From: Simon Davis
Sent: 29 August 2013 11:52
To: [REDACTED]
Subject: APP BR/201/13/DOC 3 Marine Drive West, Bognor Regis - discharge of conditions 3, 4 & 6

I am the case officer for your application and I have just rung and left a voicemail. My query relates to the details supplied for conditions 03 & 04.

Project:
Conversion of Care Home
3 Marine Drive West
Bognor Regis PO21 2QA
Title:

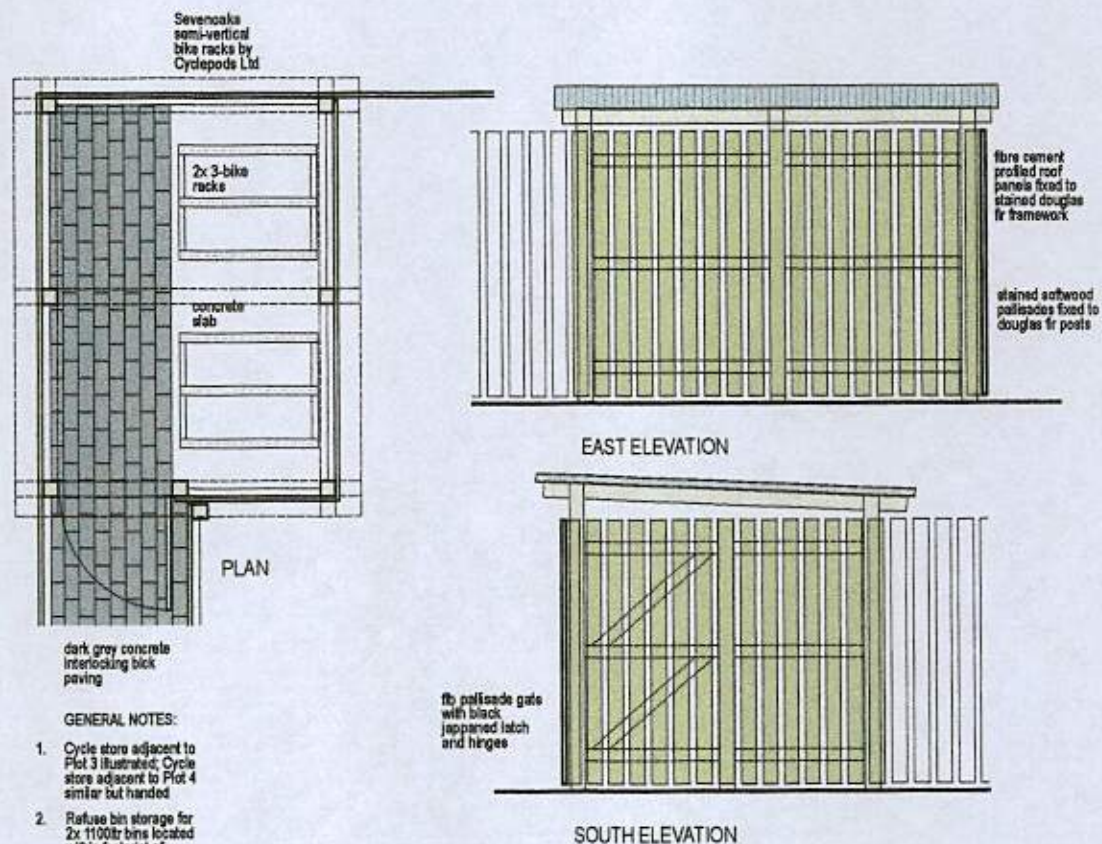
Condition 04 is for both bin store and cycle storage details. However, the submission only contains a drawing for the cycle store and nothing in respect of the bin store. Also do I assume that the location of the cycle store is as per the previously approved layout drawing? I note that on that layout drawing there appears to be two cycle stores but no bin storage. *bin store within bldg.*
